# LORSON RANCH COMMERCIAL

## TRAFFIC IMPACT STUDY

Revise to Master Traffic Impact Study

Add County Project #  
"P-22-011"

Figure 2. Lorson Ranch Commercial Site Plan

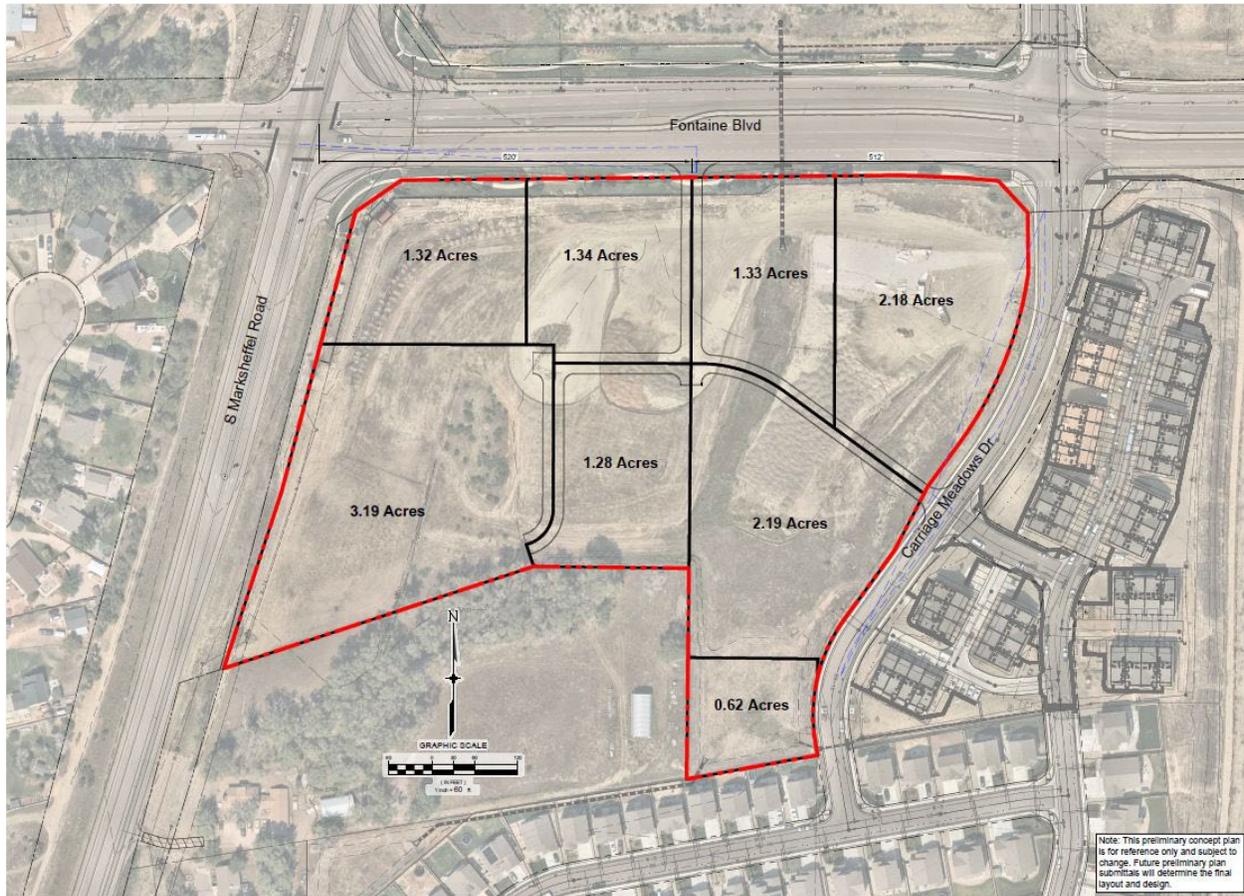
It might be helpful (but is not required) to highlight the parcel set aside for the gas station and the parcel set aside for the drainage area on the map.

Figure 3. Existing Conditions Traffic Volumes (AM Peak Hour)

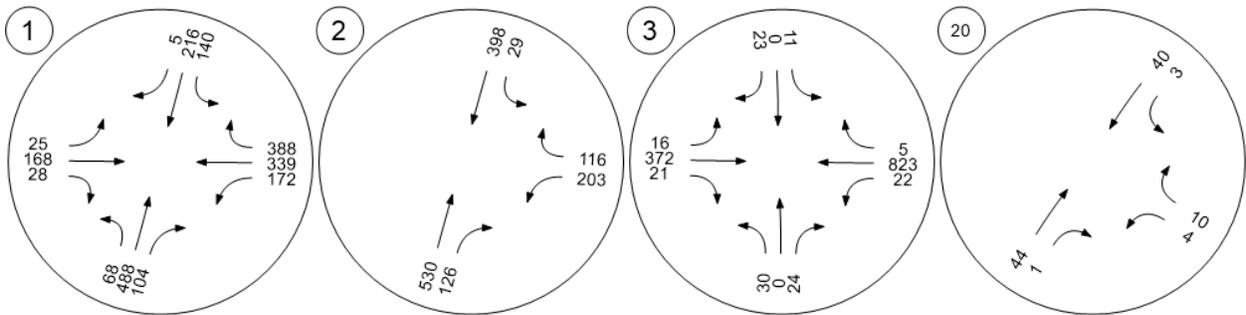
Did not see data for this intersection in Appendix A

Figure 7. Trip Distribution

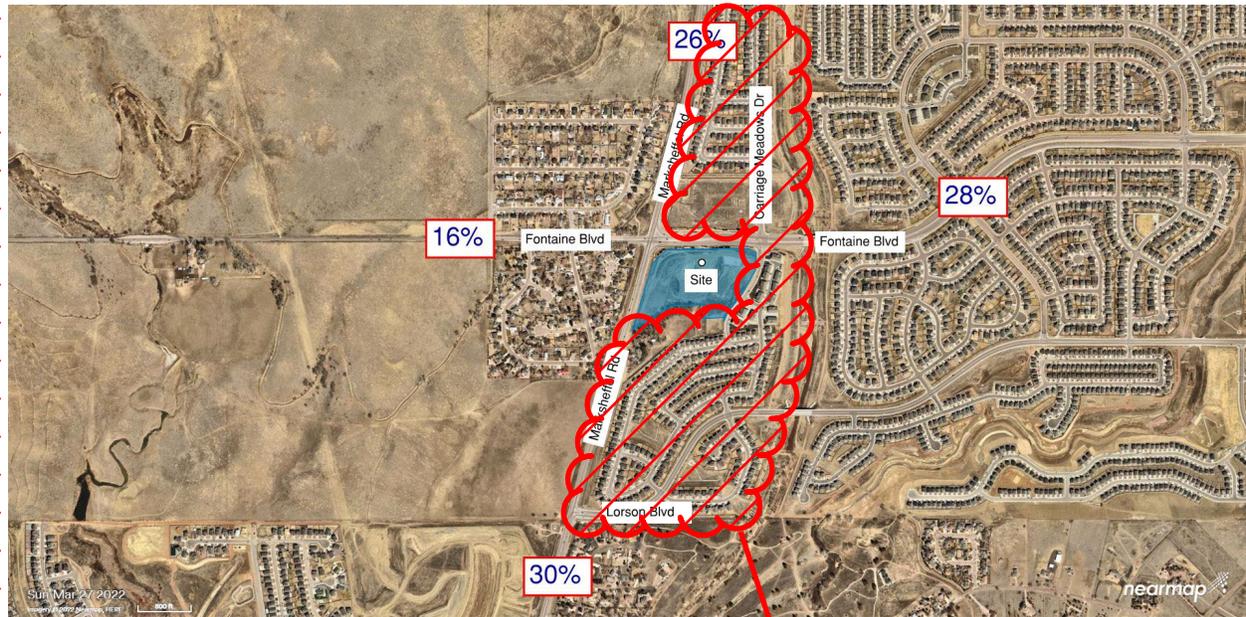
Internal capture should not be applied per NCHRP 684.

Provide source for pass-by trip credits

Will there be trips between these areas and the commercial center?

Existing travel patterns will change rapidly in this developing area. Existing volume distributions should not be the only basis for trip distribution. Refer to other studies listed on page 9.
